Kittitas County Community Development Services

RE: B & T Family Short Plat (SP-05-35)

The Kittitas County Community Development Services Department has determined that the B & T Family Short Plat is a complete application and hereby grants **conditional** preliminary approval subject to the following conditions:

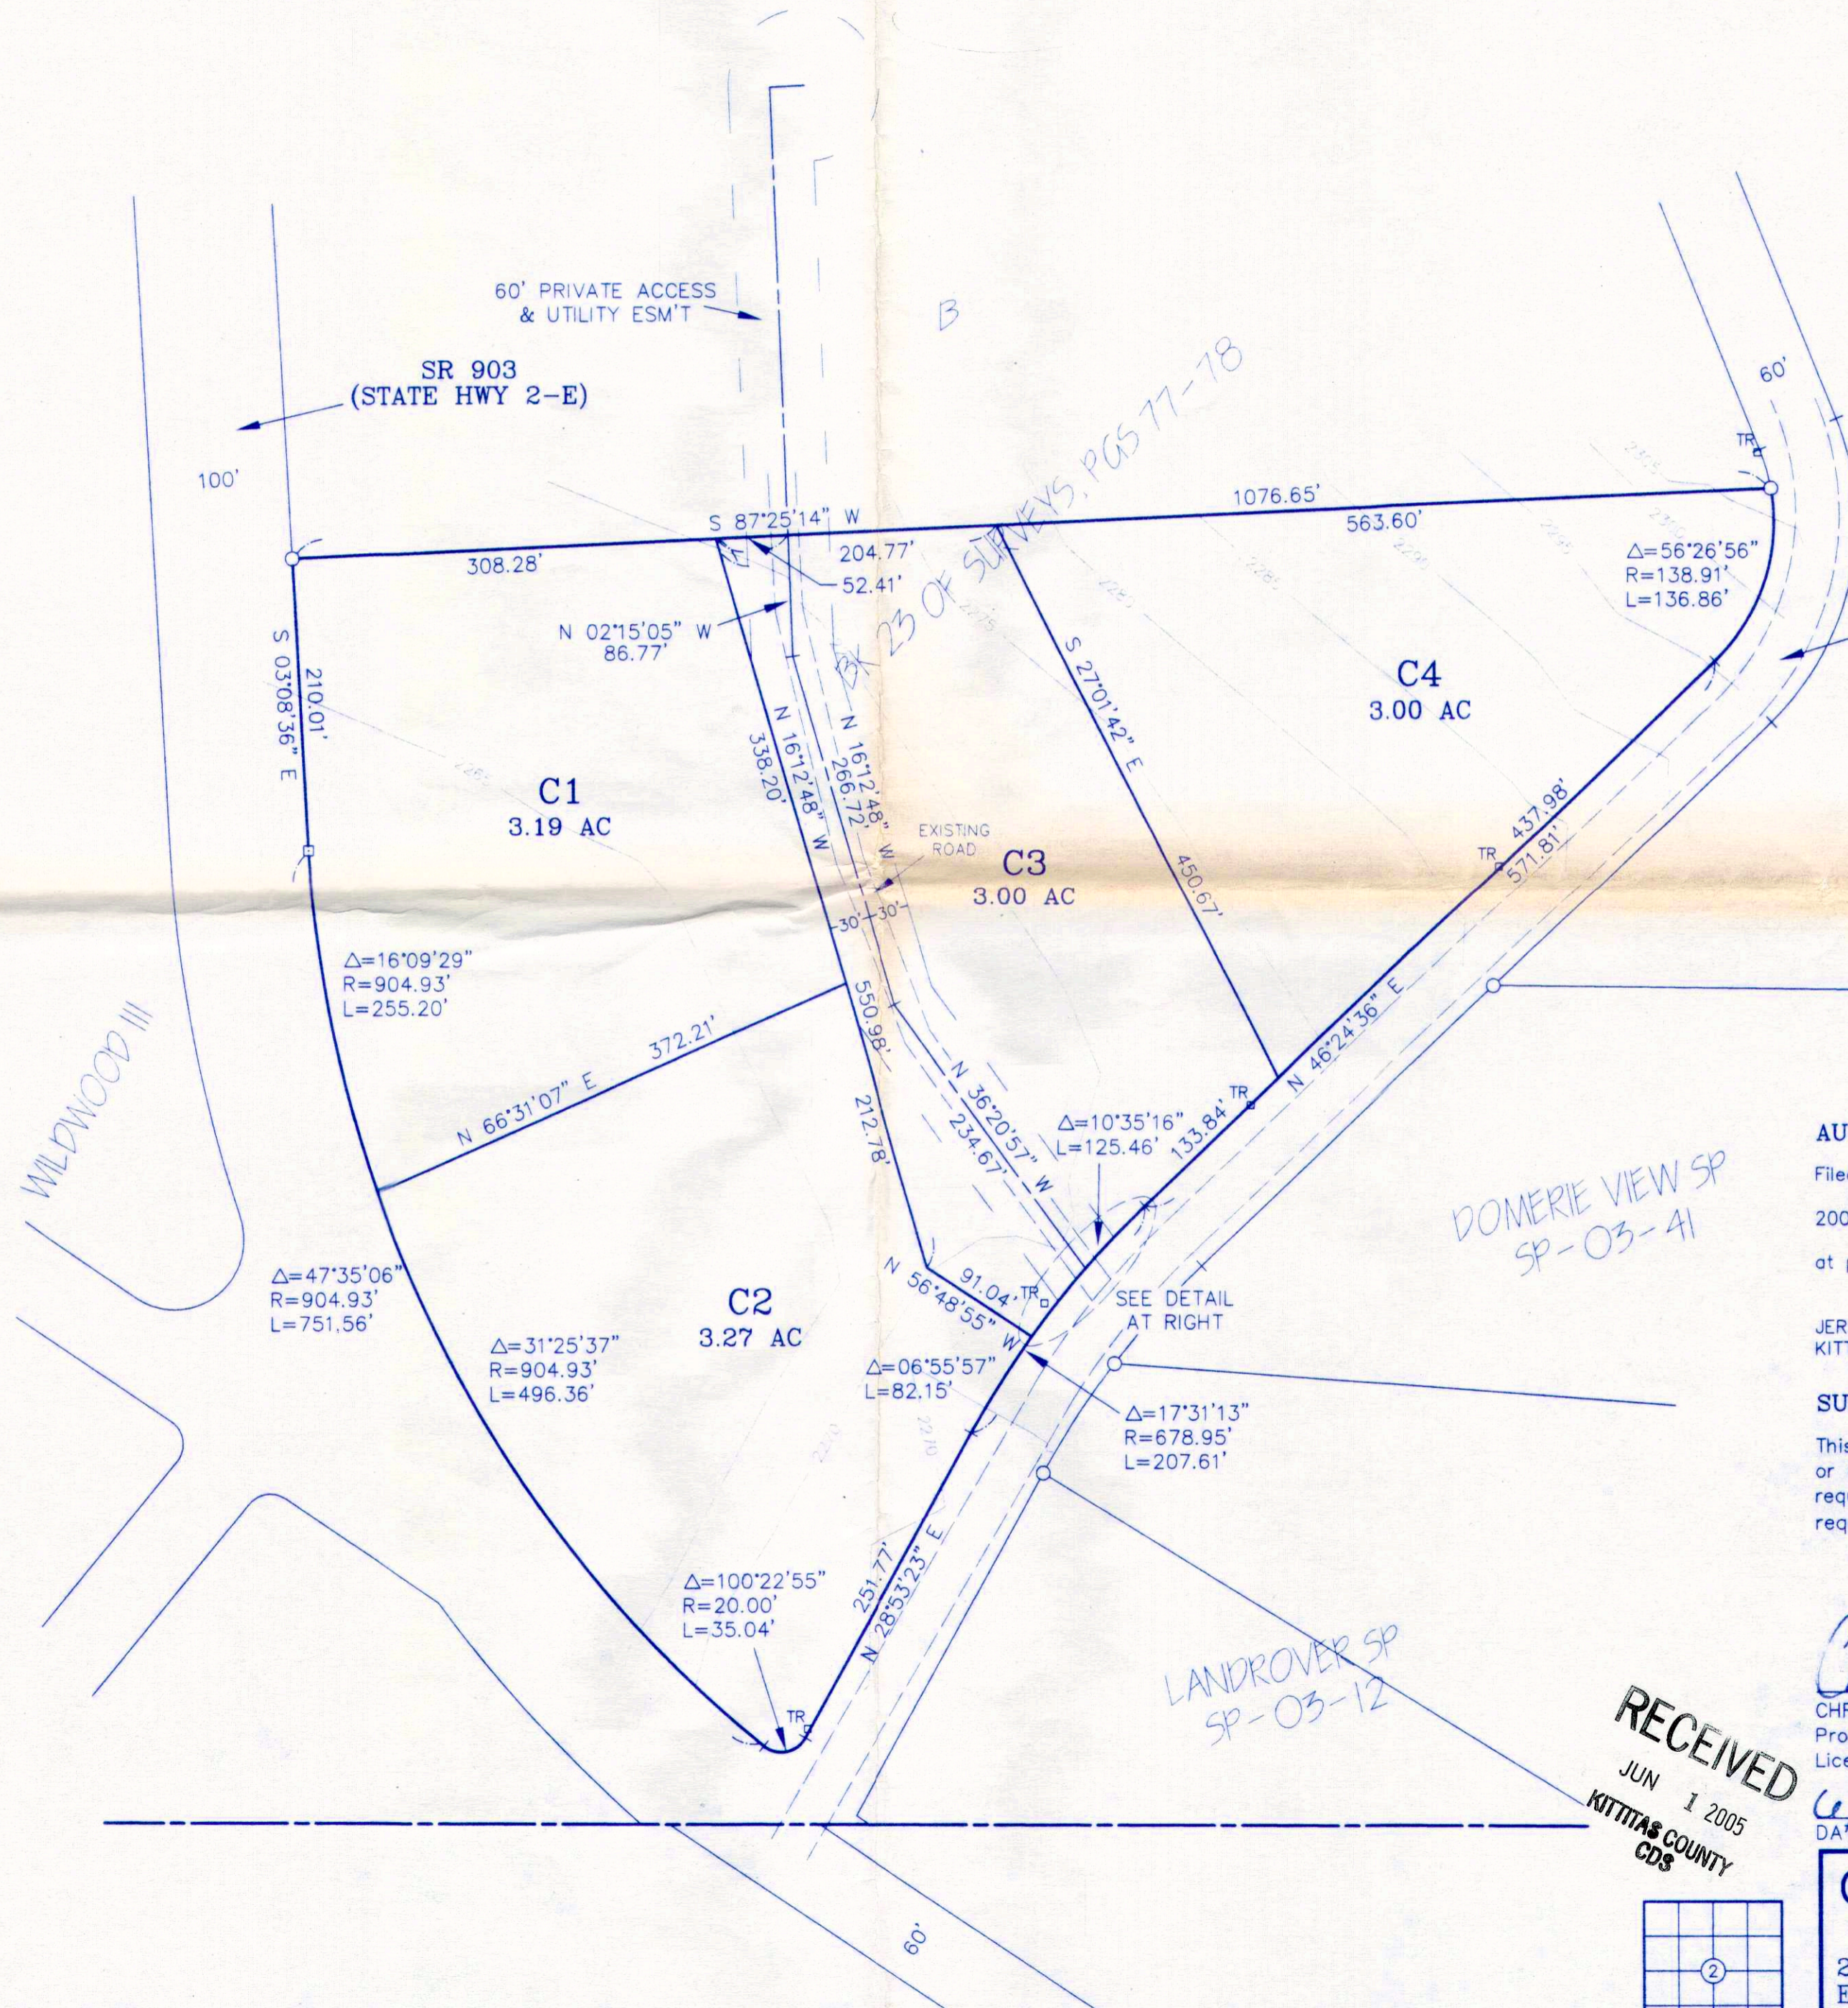
1. Both sheets shall reflect the short plat number SP-05-31.
2. **Attached you will find comments from the Kittitas County Department of Public Works and KC Environmental Health and Washington State Department of Transportation. Please see those documents for required plat notes and information on issues needing completion before final approval of this short plat.**
